**State Significant Development Application and Variation of the Sydney Cove Redevelopment Scheme for the “Remediation, Renewal and Adaptive Re-Use of Campbell's Stores”, The Rocks (SSD 7056)**

I object to the proposed development, particularly the appropriateness and design of a new four-storey glass box to the north of Campbell's Stores. This is an intrusive and ill-conceived structure that will have negative visual impact, diminish the heritage significance of Campbell's Stores and result in the loss of the opportunity for improved public access and landscaping to the foreshore of Campbell's Cove.

DIAGRAM SHOWING Proposed envelope of Bay 12 with relevant RL's

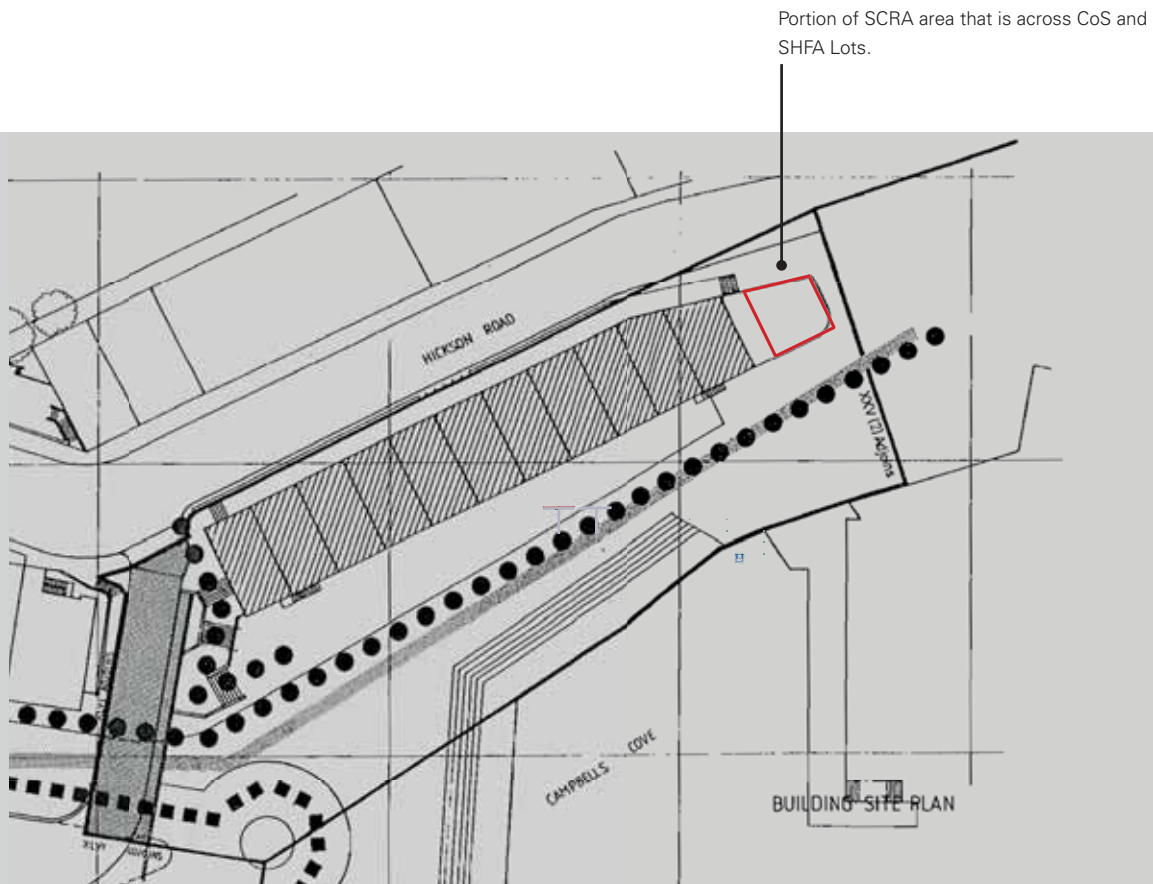
- The proposed glass box would be located next to Bay 11 on the northern elevation of Campbell's Stores. When measured from the proposed new ground level, it would be 13.3 metres high with the inclusion of its 1 metre high lift overrun. This exceeds the height restriction on the foreshore frontage by 14.5m, more than 250% and on the Hickson Road elevation by 10.5m, or 140%. **This would require a significant spot re-zoning under the Sydney Cove Re-Development Authority Scheme (SCRAS). One-off variations to this should not be permitted in advance of the Premier's holistic review of planning for the Sydney harbour foreshore.**

Another typical example of the apparent deception is the diagram on page 96 of the Design Statement shows that the glass box would be one full storey higher than the gutter level of Campbell's Stores and then there'd be the lift overrun on top of that! There's a lot of detail and information conveniently included in those diagrams that is not evident elsewhere.
